Arcadis Australia Pacific Pty Ltd  
Level 16, 580 George Street  
Sydney NSW 2000  
Tel No: +61 2 8907 9000  
www.arcadis.com/au

18/11/2020

## Harbourside Shopping Centre Redevelopment DA (SSD-7874) – Response to Submissions

Image 114 Basement access, and Darling Drive drop off locations

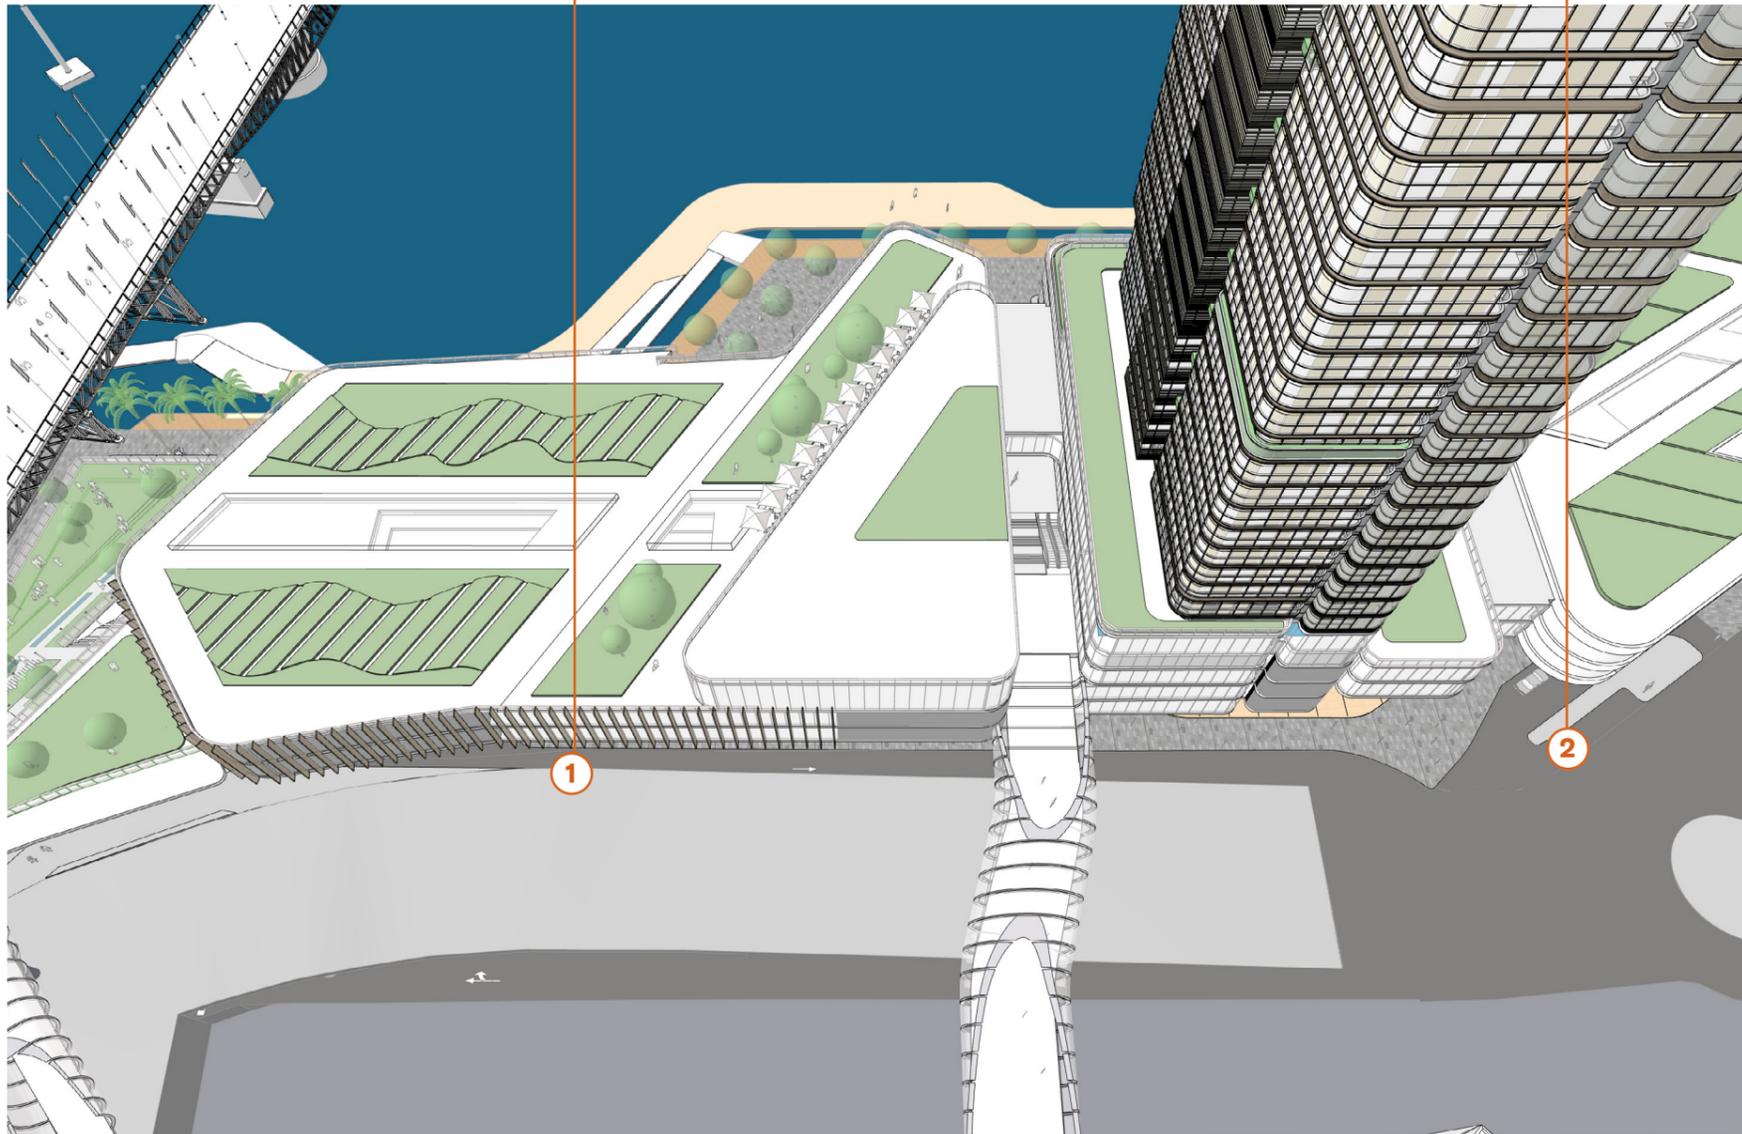
*"In response to submissions the proposed vehicular drop-off has been reviewed and revised. The concept now involves a drop-off facility with an entry at the bottom of the down ramp and egress from the existing roadway adjacent to the Sofitel hotel. Arcadis have completed a swept path analysis, capacity testing and traffic modelling to prove up this concept. Further detailed design modelling will be completed during the next phases of the project."*

It is advised that the vehicles queuing to access this drop off zone, the car park and loading and servicing would have potential to cause delays to vehicles travelling on Darling Drive.

- Queuing analysis and/ or traffic modelling to demonstrate the drop off area has adequate capacity and propose mitigation measures to ensure queuing on Darling Drive does not occur, to the satisfaction of TfNSW; and
- Prepare draft management plans for Drop-off and Pick-up Zone and Carpark and Loading Dock to manage vehicles accessing the site.

Access to the loading docks and basement car park is via the existing entry and exit roads that service the existing loading dock, which is located off the existing Darling Drive roundabout. This access road services the Harbourside development only and is not considered part of the wider public road network.

The length of the proposed access road that links Darling Drive to the loading dock and basement car park is approximately 100m. As such, this access road can accommodate up to seven queued 12.5m HGV on entry to the loading dock. As such, it is unlikely that queued vehicles entering the loading dock will impact on the operation of Darling Drive.

The length of the entry access road to the basement car park is approximately 150m from the car park entry to the interface with Darling Drive.

Table 3.3 of AS:2890.1 Off-Street Car Parking outlines peak hourly in-flow of traffic and queue areas required for car parks with boom gates and ticket issuing devices at entry points. Applying the criteria outlined in that

table would require a vehicle queue storage allocation of 19 vehicles. Applying 6m for a vehicle footprint would equate to a queue storage length of 114m, which is less than the 150m provided. This assessment is a robust assessment and detailed modelling would likely reduce this number.

As such, traffic queued entering the basement car park is unlikely to impact the operation of traffic on Darling Drive.

The Drop-off and Pick-up zone will operate as a Kiss & Ride facility and will include a travel through lane. As such, vehicles will not occupy vehicle bays for a long time, and in the event that all bays are occupied on vehicle approach, vehicles can bypass the zone without blocking traffic on Darling Drive.
